WEST SUSSEX COUNTY COUNCIL CONSULTATION

TO:	Arun District Council FAO: Simon Davis
FROM:	WSCC - Highways Authority
DATE:	27 September 2019
LOCATION:	Land Adjacent to 34 Wakefield Way Aldwick PO21 3RS
SUBJECT:	AW/246/19/PL Erection of 1 No. 2 storey end of terrace house.
DATE OF SITE VISIT:	n/a
RECOMMENDATION:	Advice
S106 CONTRIBUTION TOTAL:	n/a

PROJECT	Wakefield Way	DATE	19/08/19
TITLE	Site Plans	DRG NO	IBA/520/01
SCALE	As Noted	REVISIONS

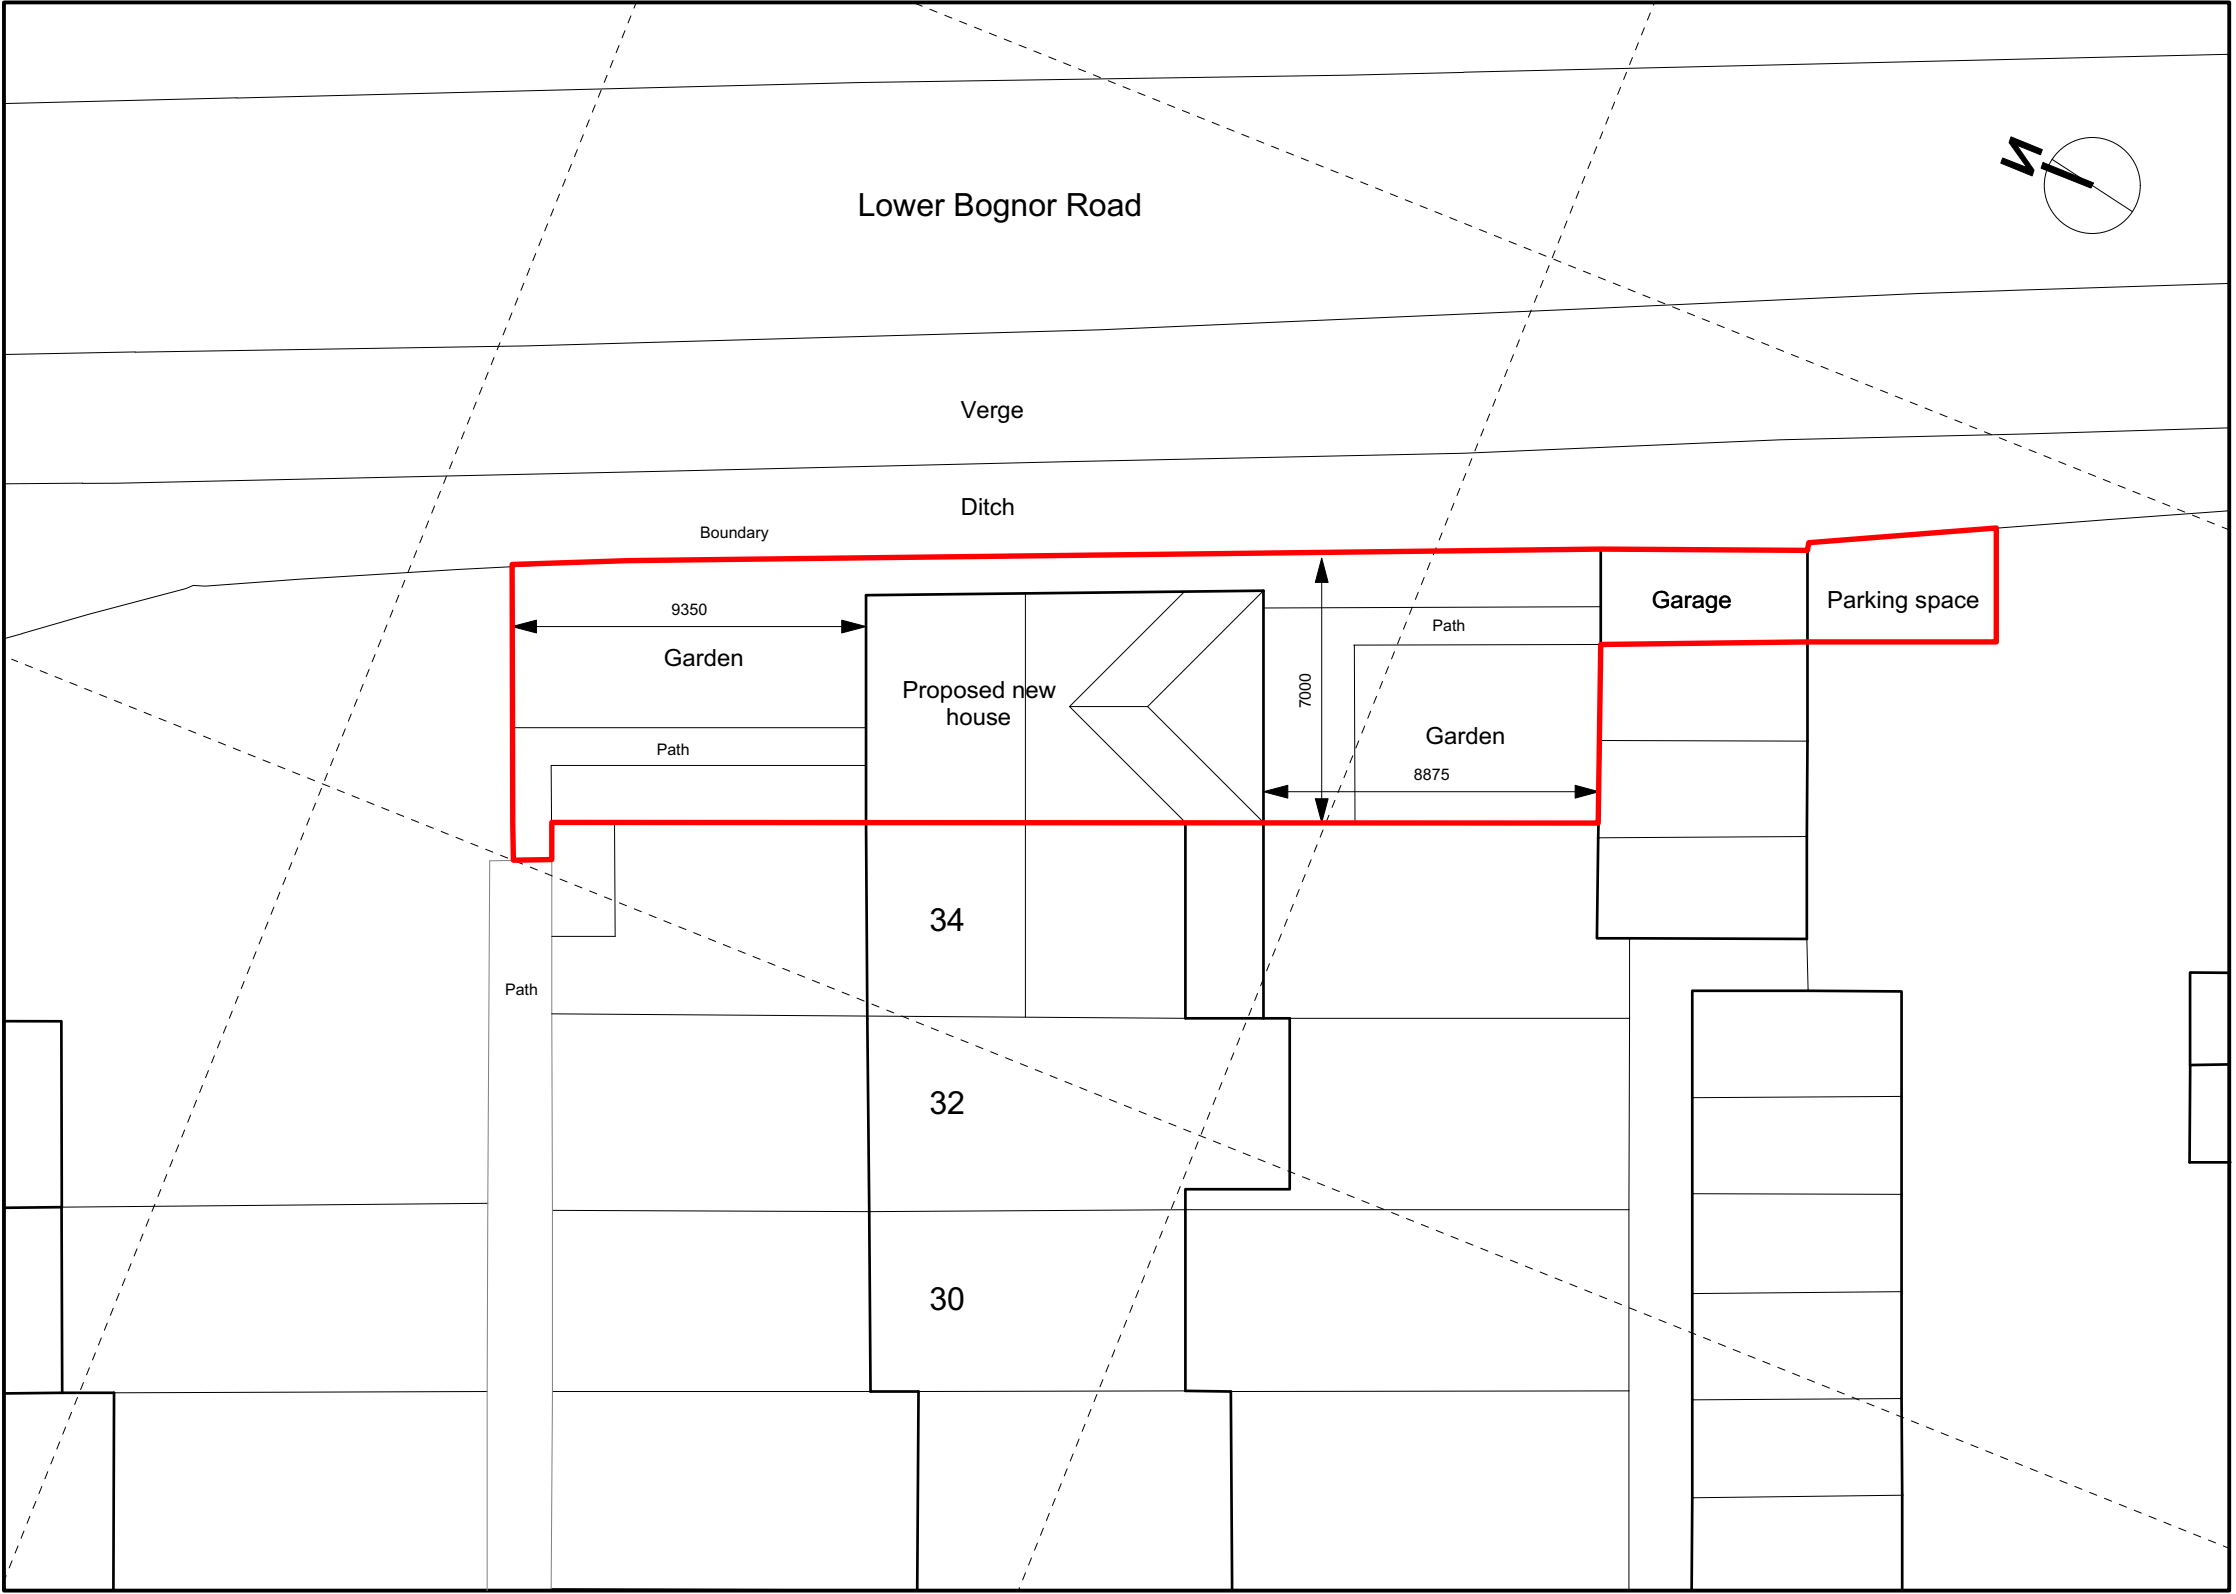
The existing garage alongside with a hardstanding area in front of the garage is the proposed parking provision for the new dwelling totalling of 2 parking spaces. WSCC Car Parking Demand Calculator (PDC) (updated August 2019) requires 3 parking spaces to be provided for this size dwelling, on this location. The existing garage is allocated to the new dwelling which leaves no 34 Wakefield Way with nil parking provision.

Although allocated to the new dwelling, the garage would not ordinarily be considered as a parking space, as it does not meet the Manual for Streets (MfS) standards of 3mx6m for single garage. However, the LHA appreciate that this is an existing garage which currently provides potential parking provision for 34 Wakefield Way. As the garage measures circa 2.5mx5.5m it is possible that it could accommodate a small car. The proposed parking space in front of the garage has not been outlined within the applicant's ownership boundaries; however is outlined as part of the proposal. As this land is not within the control of the applicant, the parking space cannot be reserved or allocated to the dwelling and therefore cannot be taken into consideration when determining number of parking spaces. It is possible that a vehicle could park in front of the opposite garage in the same manner, which would remove the ability for a vehicle to manoeuvre into or out of the proposed space.

As such, the LHA would consider that a maximum of one parking space is available to the proposed dwelling. The Local Planning Authority (LPA) may wish to consider the likely overspill parking as a result of the loss of garage for 34 Wakefield Way and the shortfall of one parking space for the proposed dwelling from an amenity point of view.
